5 March 2026

Our Ref: PRO-10406-B2X9

251-257 Maroubra Road, Maroubra NSW 2035
BCA2022A2 Consistency Statement for Development Application (DA) Lodgement

Source: BKA Architecture, Project No. 24029, Drawing No. DA093, Rev A, Date: 12/2/2026, Basement 01 Floor Plan

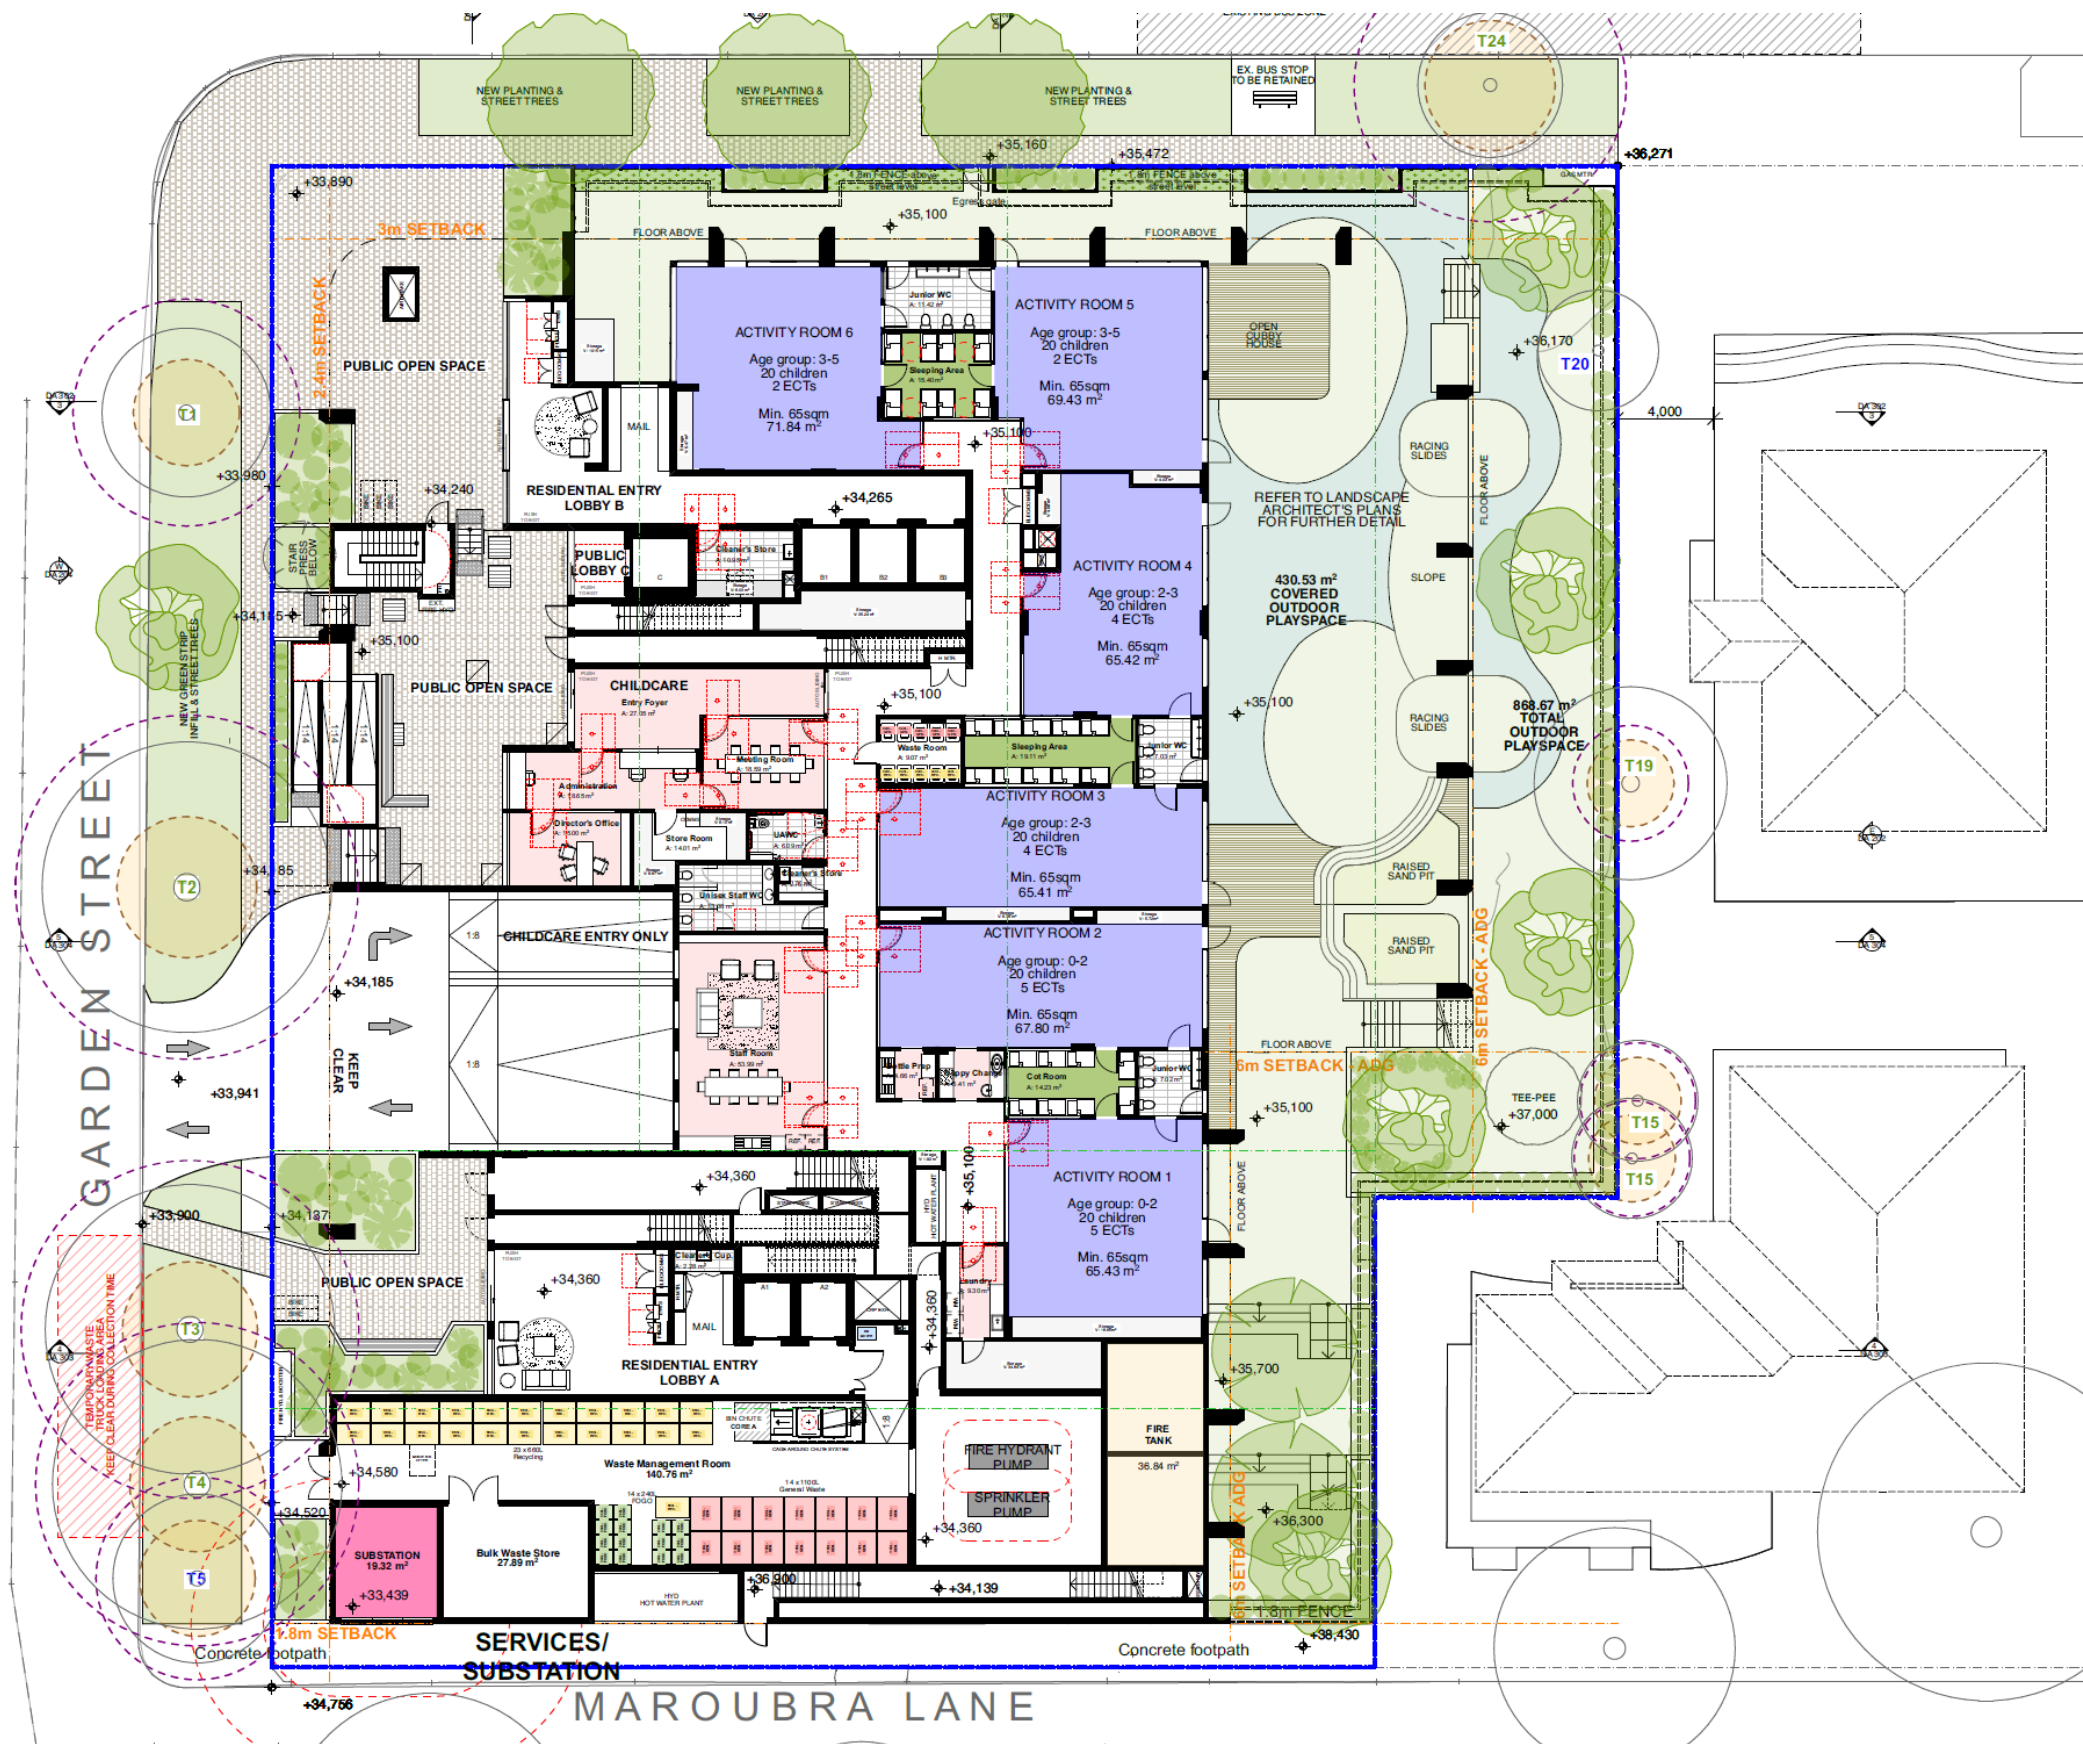
- **Clause C2D2 & Spec 5** – The Basement 1 and Ground Floor garbage rooms are to be enclosed with FRL 120/120/120 construction and fitted with FRL –/120/30 fire doors in accordance with Specification 5 of the BCA.

- **Clause D3D24 & D3D26** – The subject roller shutter doors within the Basement carpark are required to be provided with a performance solution as per Clauses D3D24 and D3D26;

- **Clause D3D22** – The subject fire isolated stairways serving the basement levels require a single handrail along one side of the stairway in the path of travel;

- **Clause D4D2** – 850mm clearance through the active door leaf does not appear to be provided to the bin chute rooms on the residential levels;
- **Clause D4D4** – Sufficient turning spaces and dead end zones appear to have been provided within accessways required to be accessible in accordance with AS1428.1-2021, with the exception of numerous turning spaces within Basement 1, Ground Floor, and the Eighth and Ninth Floor residential corridors of Building B;
